# The Planning Inspectorate

Our Ref: EN020021

### **Application by SP Manweb for an Order Granting Development Consent for the Reinforcement to the North Shropshire Electricity Distribution Network**

#### **Advice following issue of decision to accept the application for Examination**

© Crown copyright. All rights reserved.
2017 Licence number 100019036

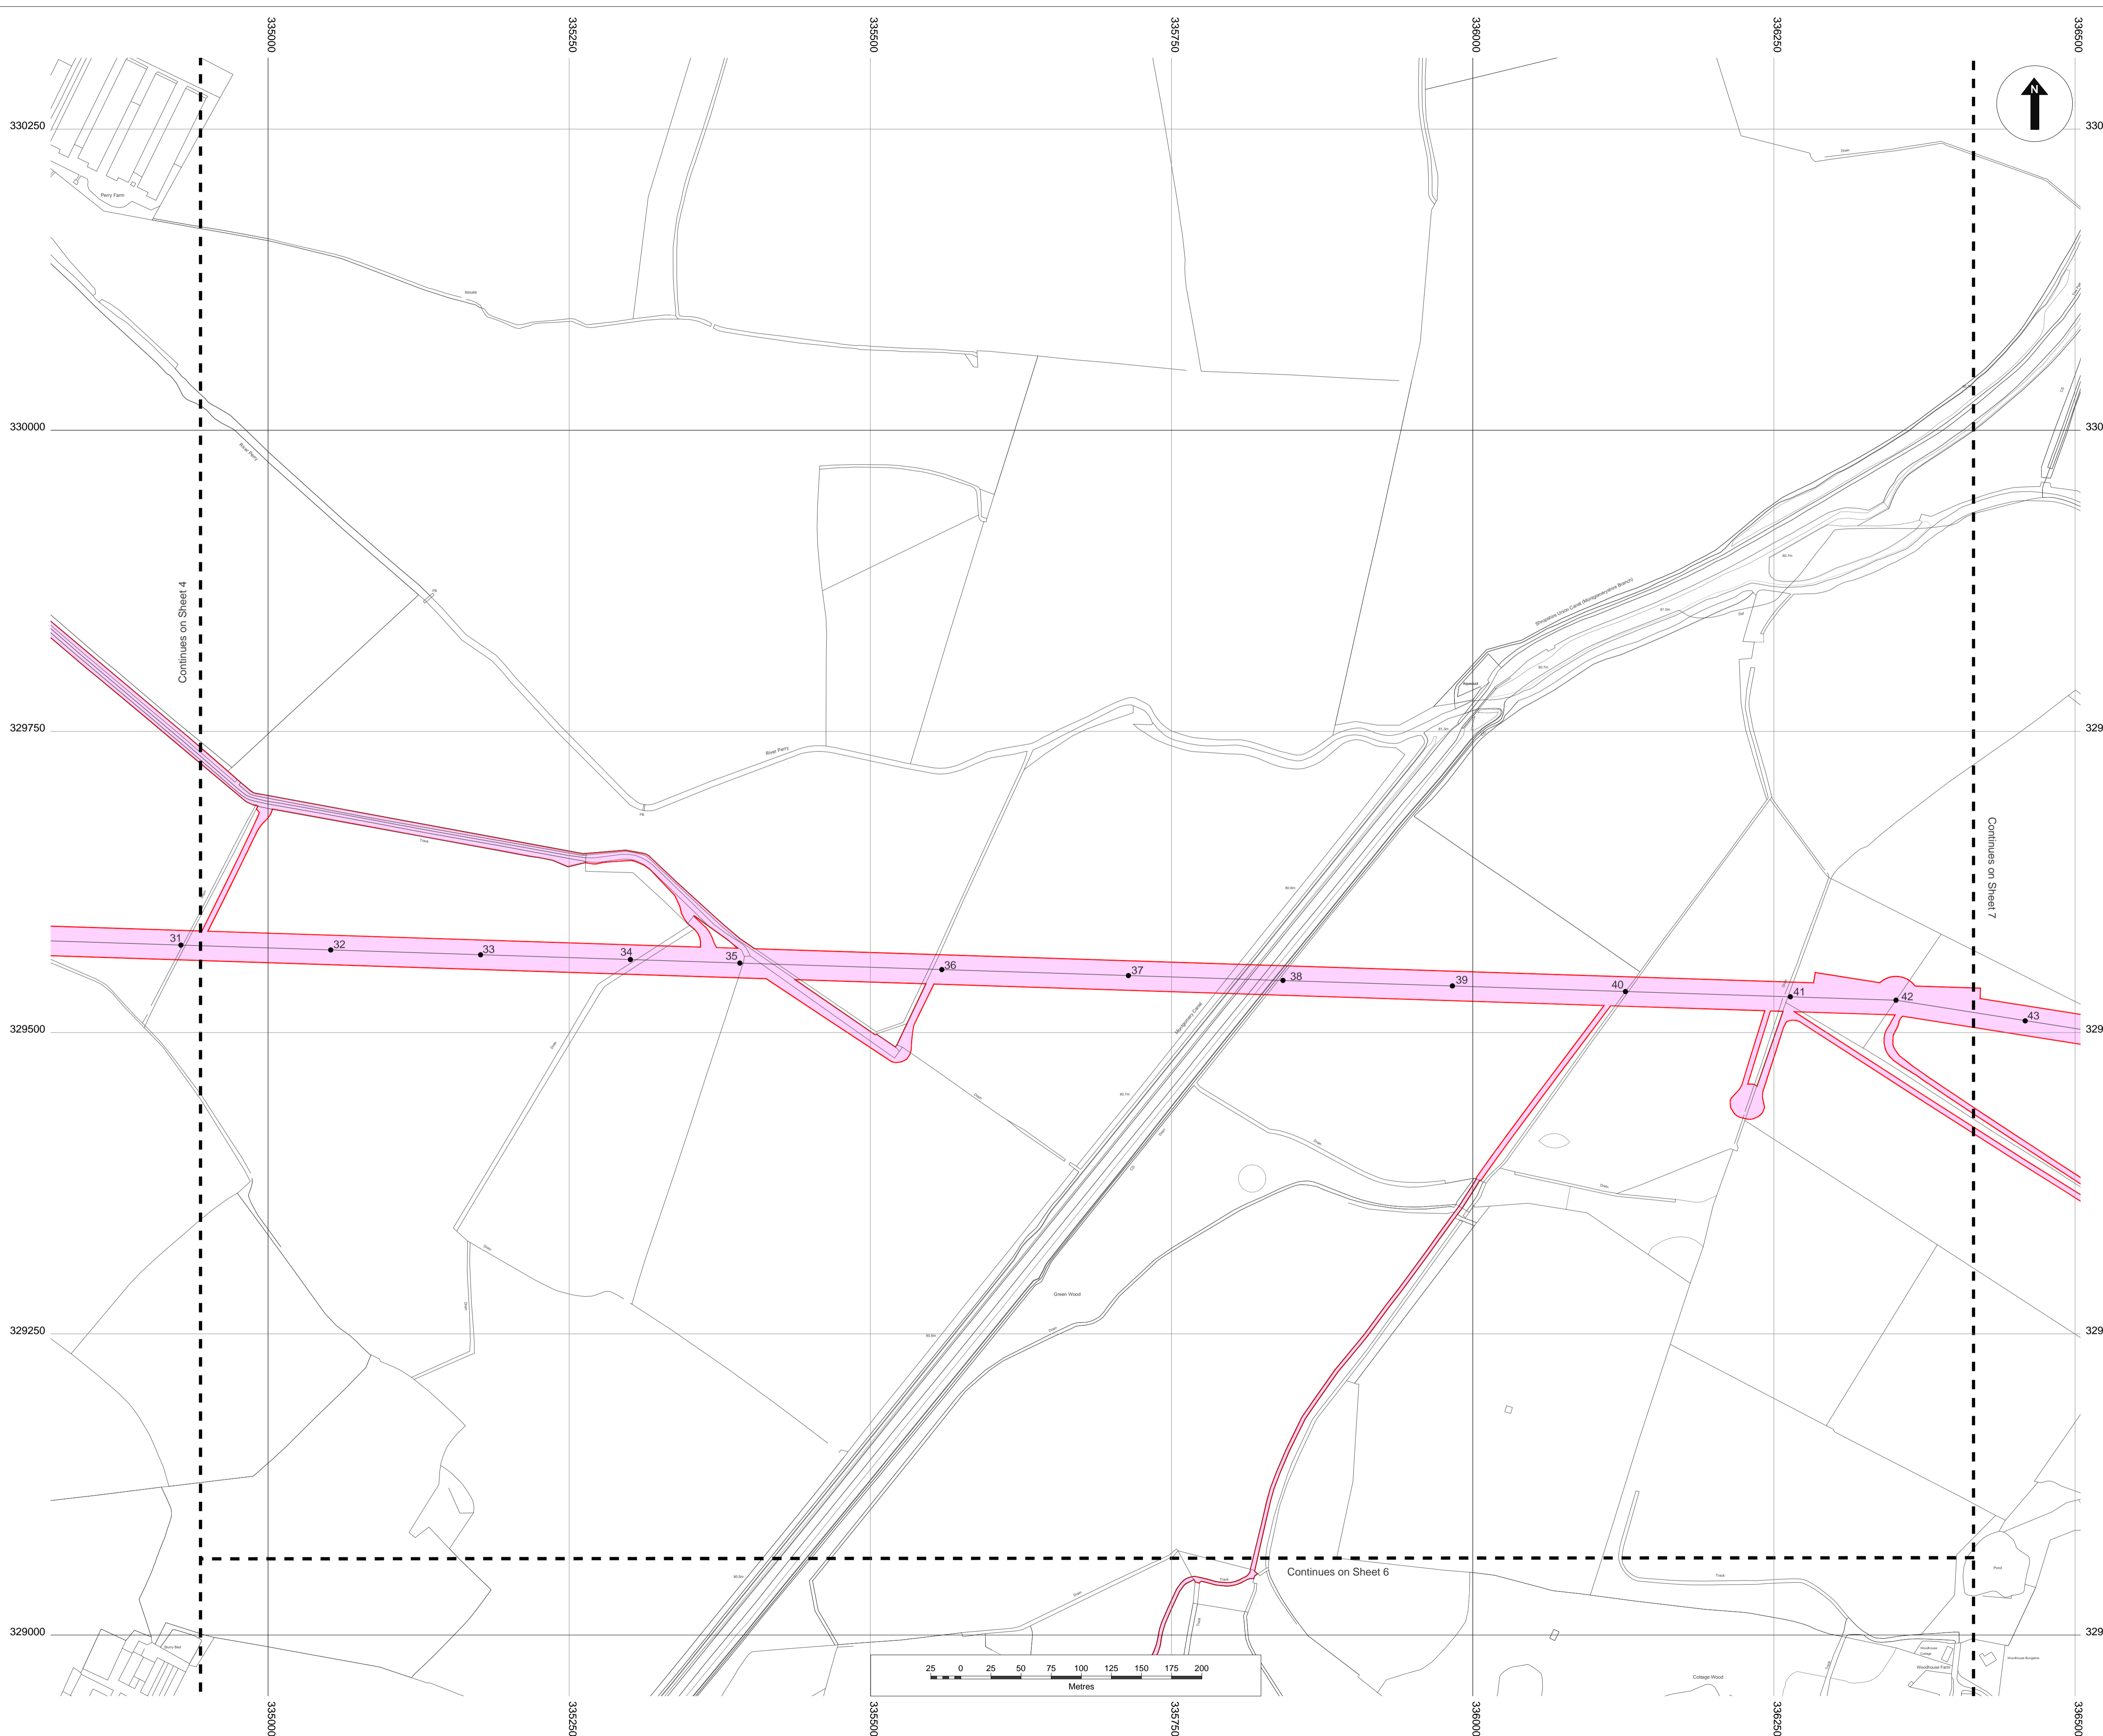
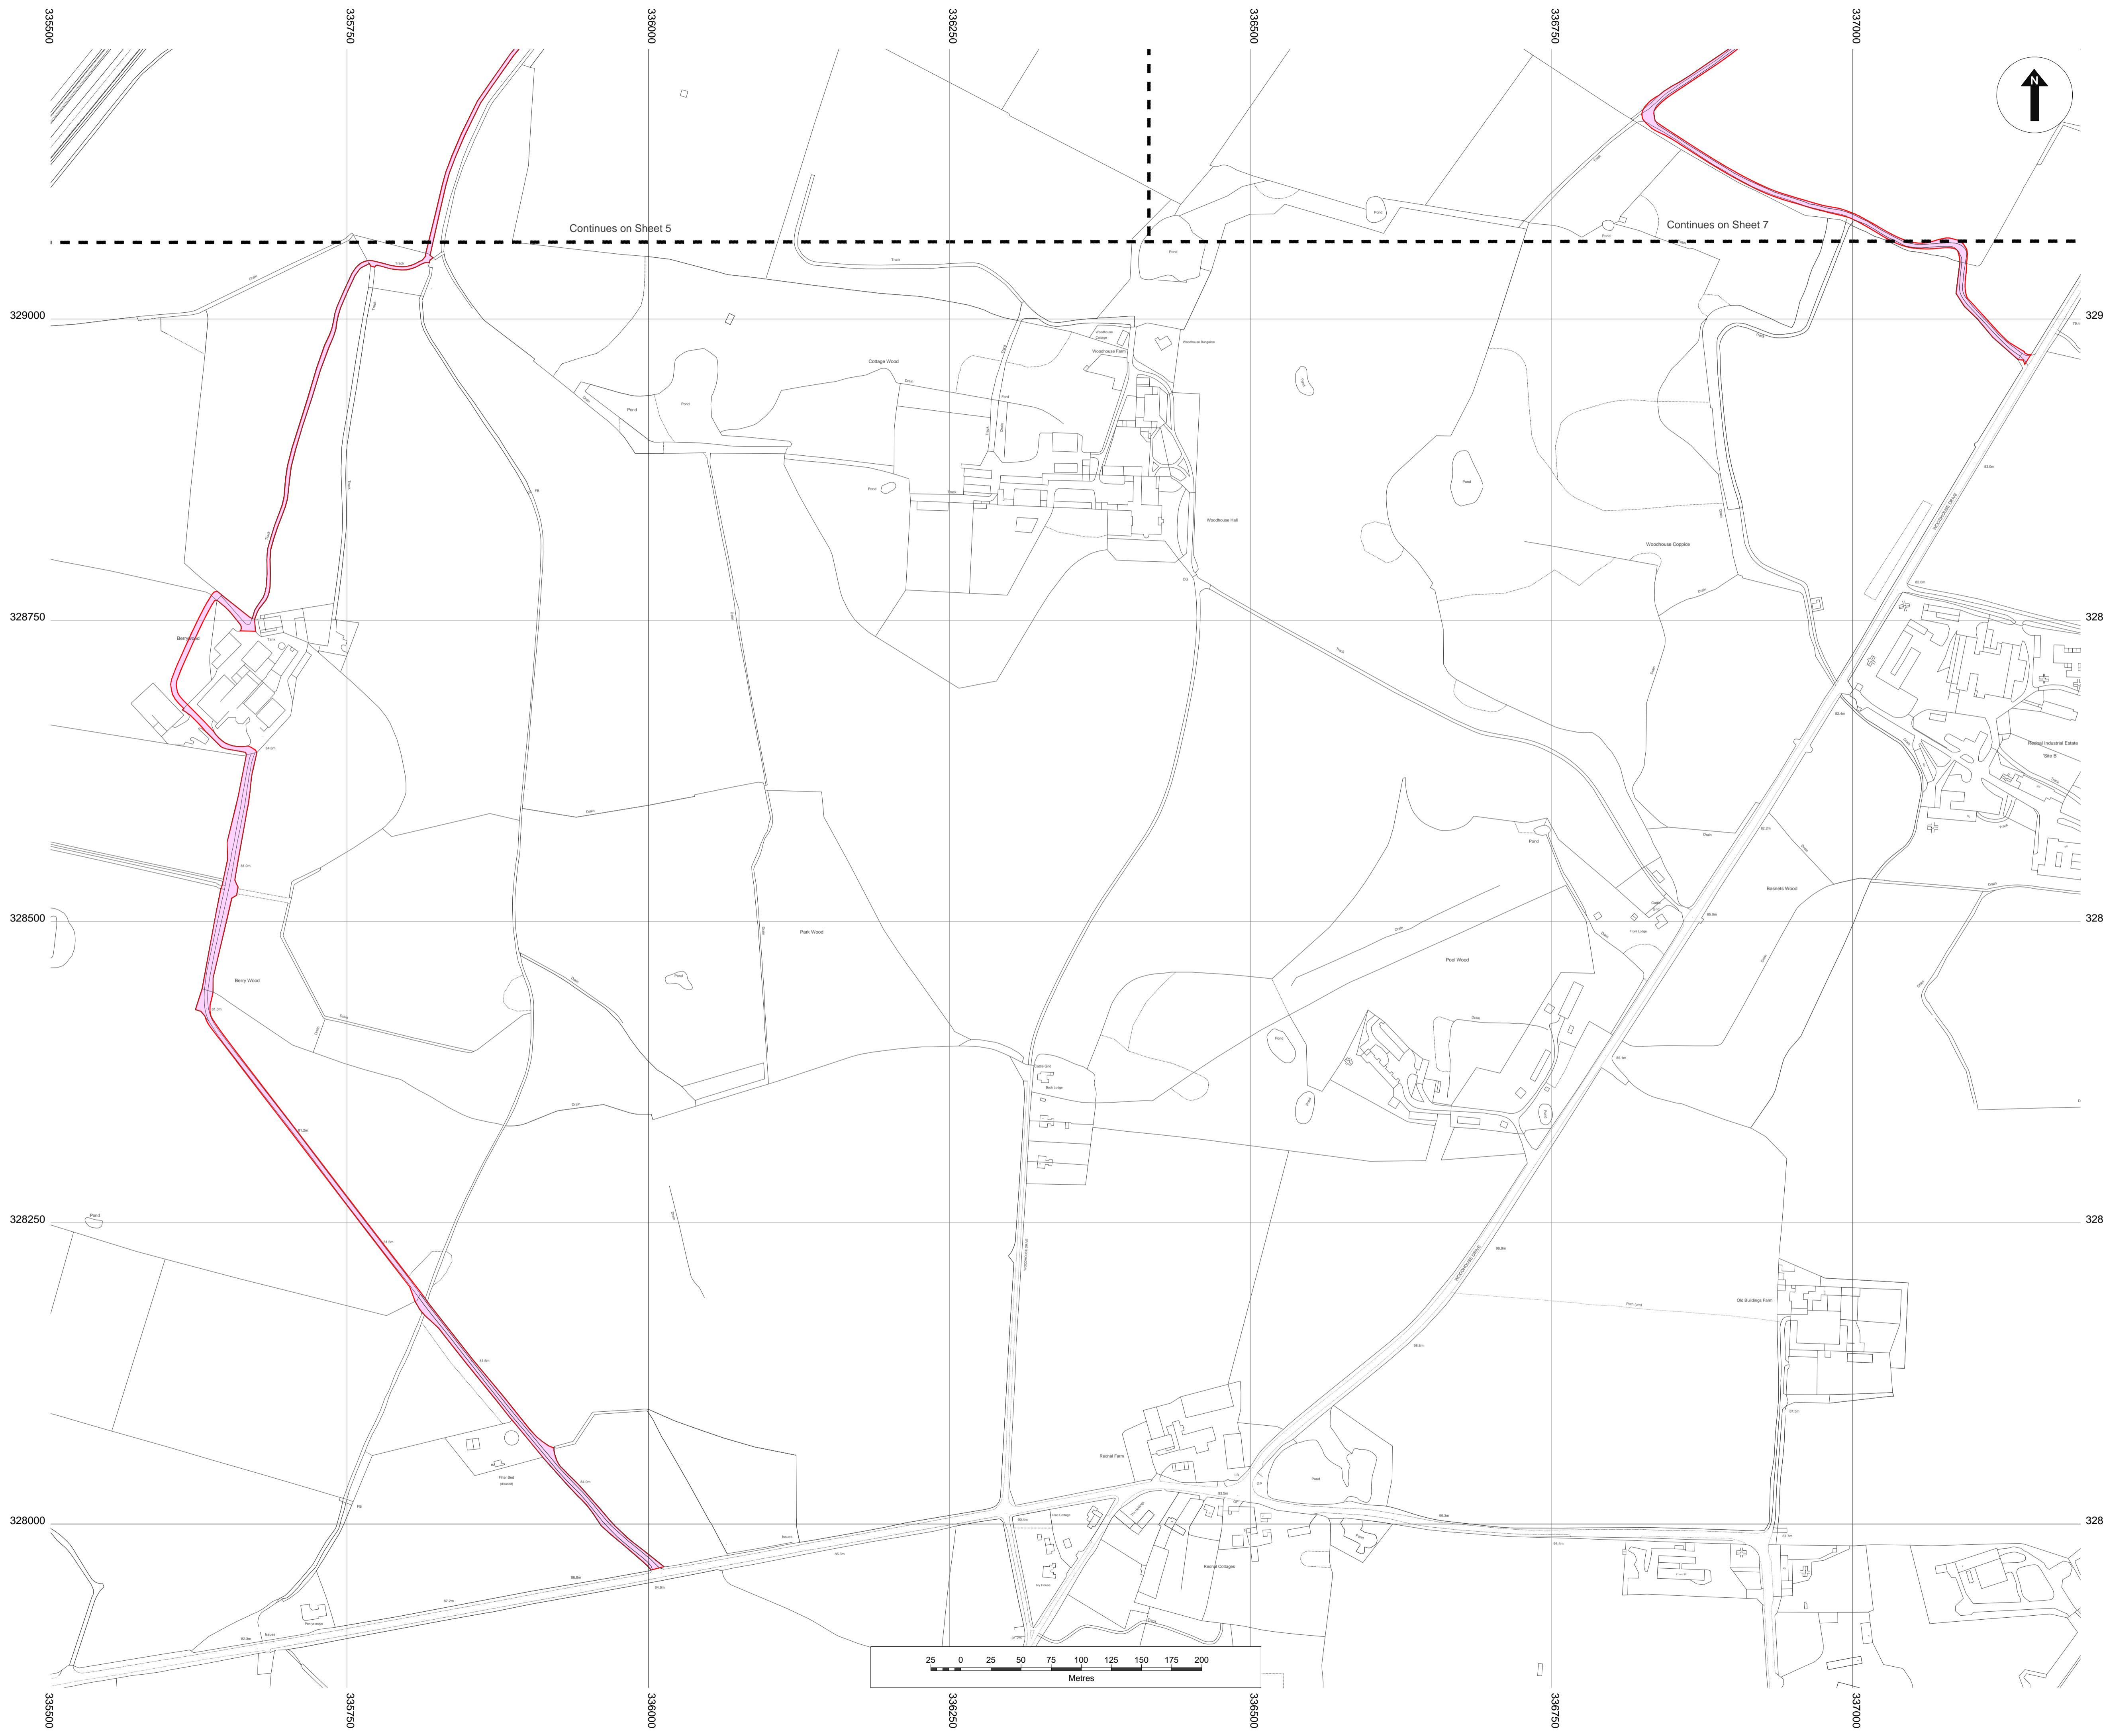
It is noted in the Checklist that the lateral limits of deviation for the poles are not shown on the Works Plans. The Applicant is advised to provide a clear explanation of the relationship between article 4(1)(a), Requirements 3 and 4 of the draft DCO, and the Works Plans, and show the limits of deviation for Work No.3 on revised Works Plans.
